BOGNOR NORTH RELIEF ROAD SPORTS PITCH ACCESS SPORTS PITCH ACCESS

DESIGNERS RESPONSE TO WSCC COMMENTS

Project no: 11030854

This report is a response to comments provided by Ian Geldhill, West Sussex County Council (WSCC) on 22nd July 2015 regarding a proposed sports pitch access design on the Bognor North Relief Road. Feedback has also been provided during meetings with WSCC, and Stage 1 and 2 Road Safety Audits have been performed with designer responses provided.

PROJECT:	BOGNOR NORTHERN RELIEF ROAD
TITLE:	SPORTS PITCH ACCESS GENERAL ARRANGEMENT

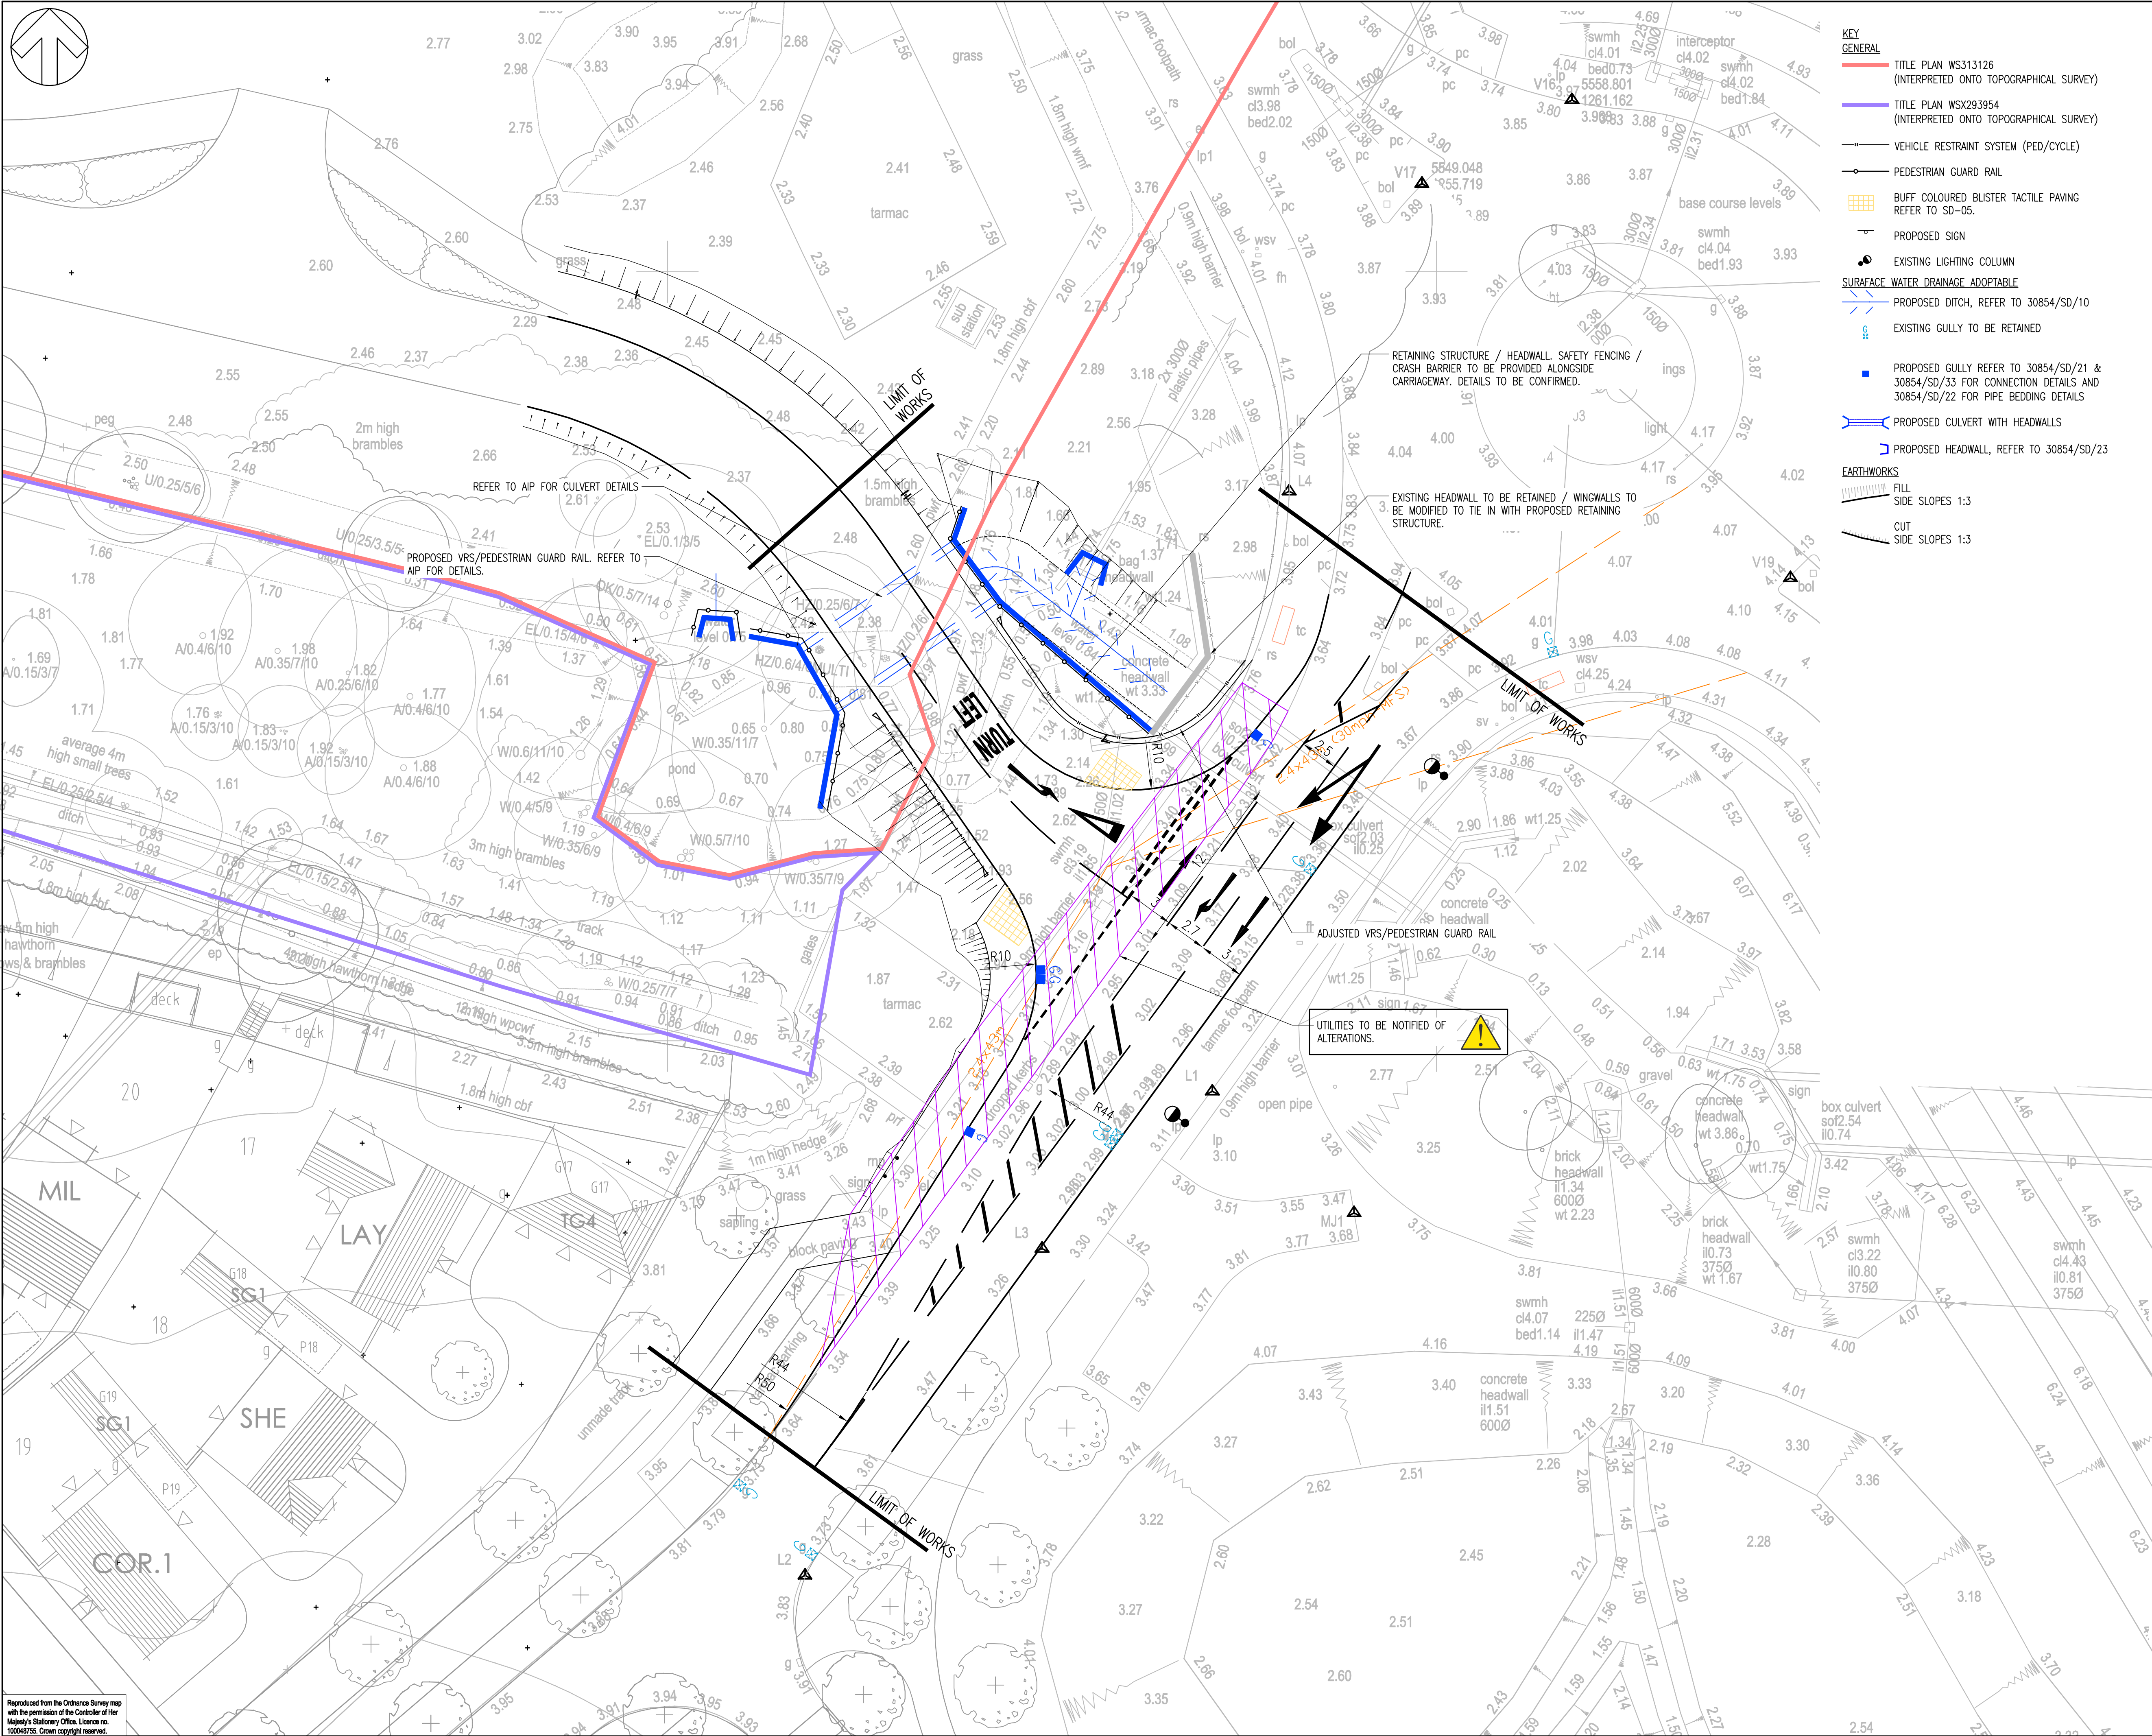
EXTEND THE RIGHT TURNING LANE LENGTH NORTHWARDS

REMOVE HATCHING WITHIN THE ACCESS

NO RIGHT TURNER EGRESS FROM PLAYING FIELD ACCESS

The direct taper of the right turning lane has been moved northwards to extend the right turning lane. The width of the right turning lane is now 2.5m at the end of the direct taper, following the absolute minimum acceptable width given in DMRB TD 42/95 paragraph 7.36.

The hatched area on the minor arm of the junction has been removed. The 1004 centreline road marking has been extended to the give way line, along the previous centre of the hatching.

The no right turner is proposed to support the basis of providing a right turn ghost island. The provision of this no right turner is an addition to the approved scheme access proposal without a right turn ghost island previous design (Dalton Crawley Partnership, Drawing D42/5250/CFB/SL-01, Rev F). .

The kerblines of the westbound lane south of the junction previously kinked outwards. The kerblines have been improved by removing this kink and straightening. The right turning lane taper has been updated to reflect this change, improving its gradient from 1 in 4.6 at its worst point to 1 in 11.1.
